# CITY OF ALBUQUERQUE

RE: **Starbucks Parking lot Changes**  
**8251 Golf Course Rd NW**  
**Grading Plan and Drainage Plan**  
**Engineer's Stamp Date: 7/23/18**  
**Hydrology File: C12D001G4**

Based on the submittal received 7/23/18, the Grading and Drainage Plan cannot be approved for Grading or Paving Permit until the following are corrected:

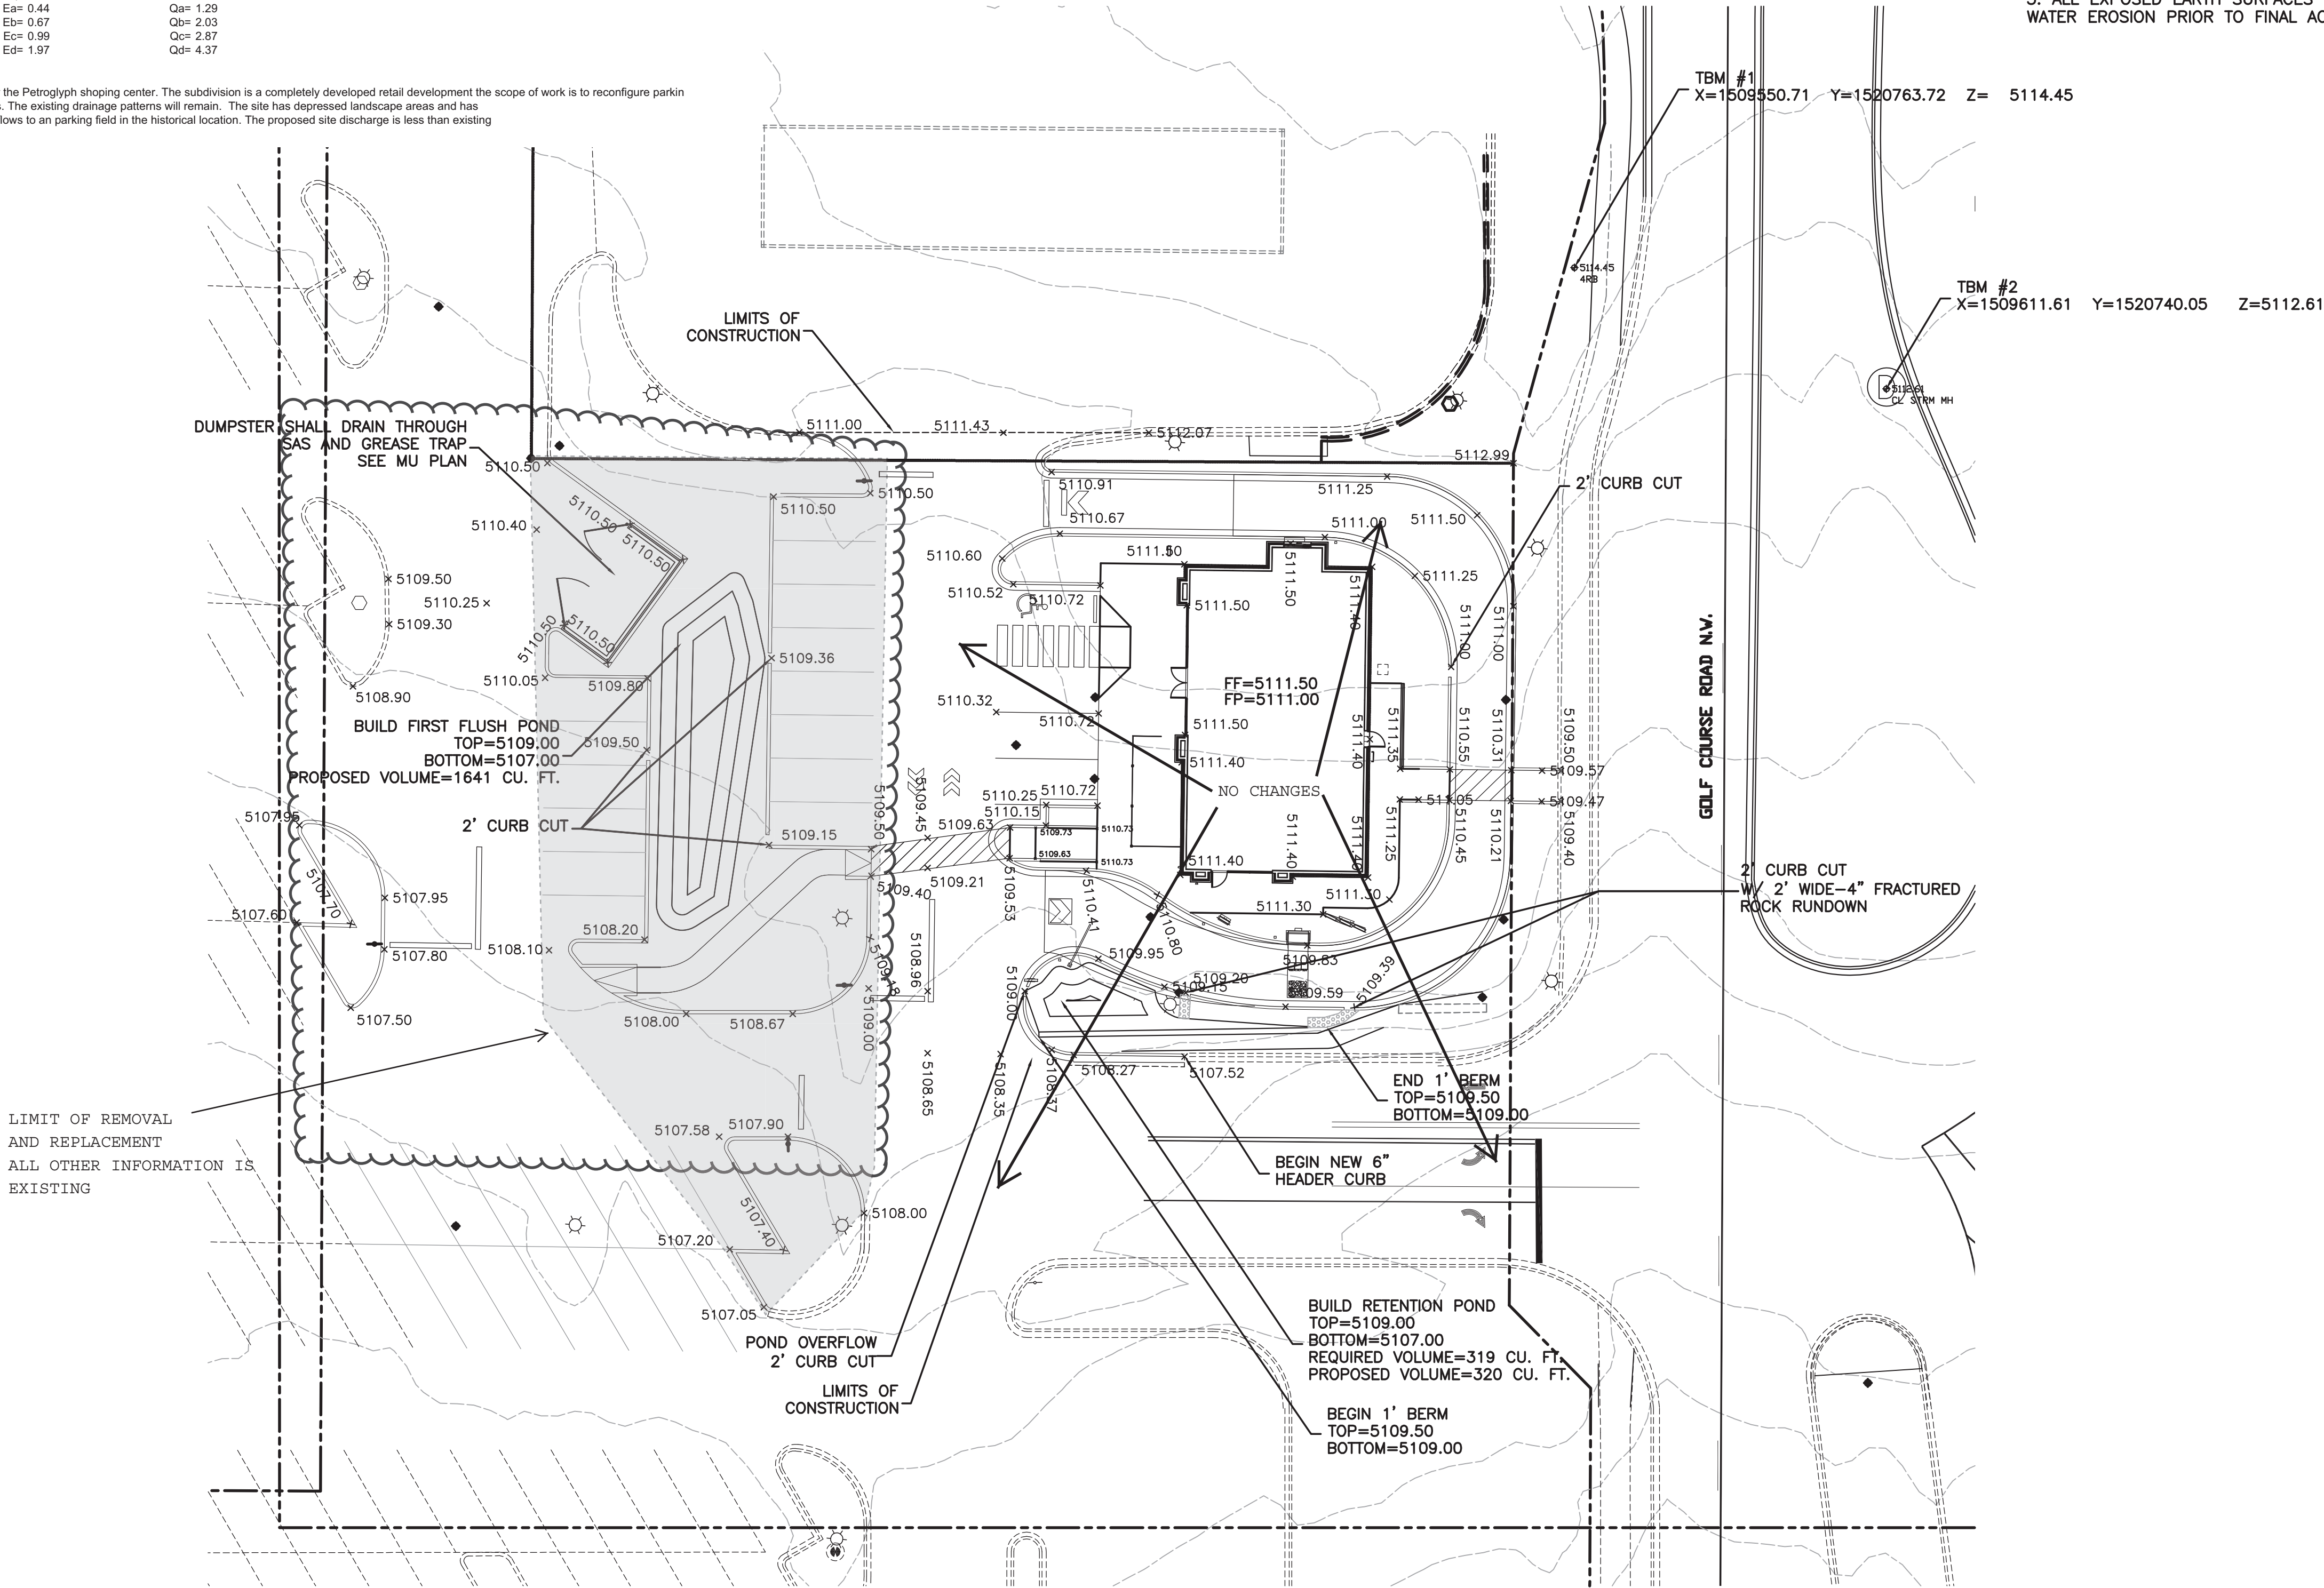
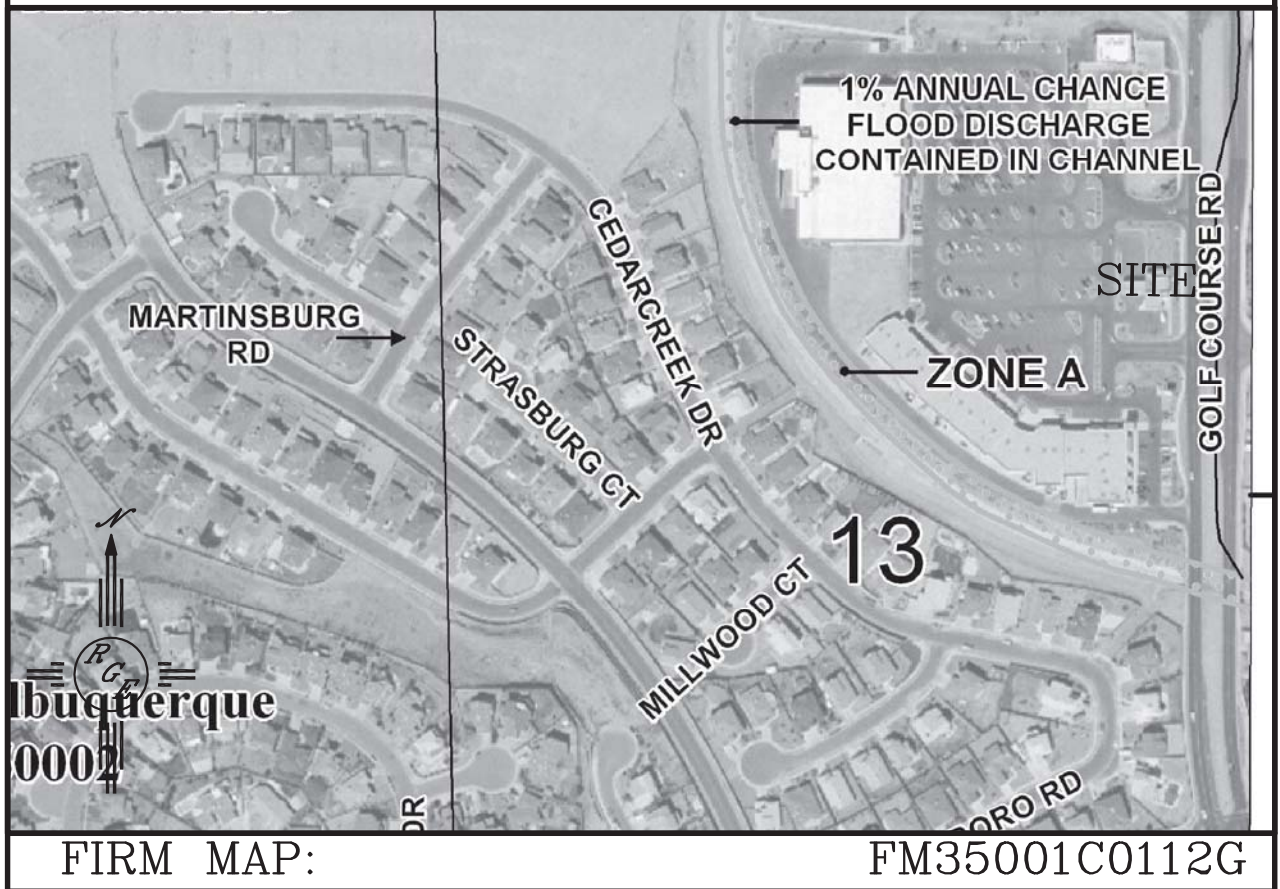
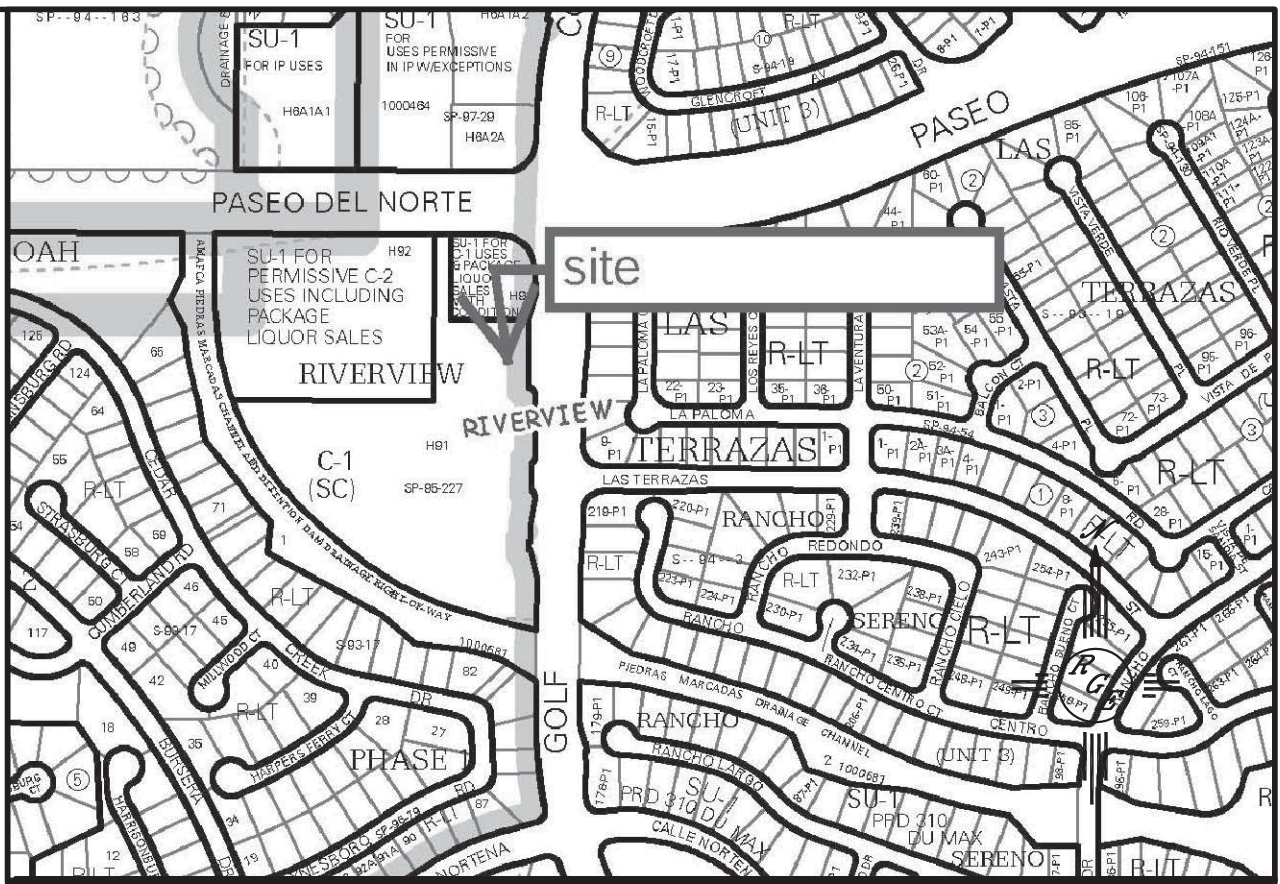
1. A Bernalillo County Recorded [Private Facility Drainage Covenant](#) is required for the first flush pond. The original notarized form, exhibit A (legible on 8.5x11 paper), and recording fee (\$25, payable to Bernalillo County) must be turned into DRC (4th, Plaza del Sol) for routing. Please contact Charlotte LaBadie (clabadie@cabq.gov, 924-3996) or Madeline Carruthers (mtafoya@cabq.gov, 924-3997) regarding the routing and recording process for covenants.
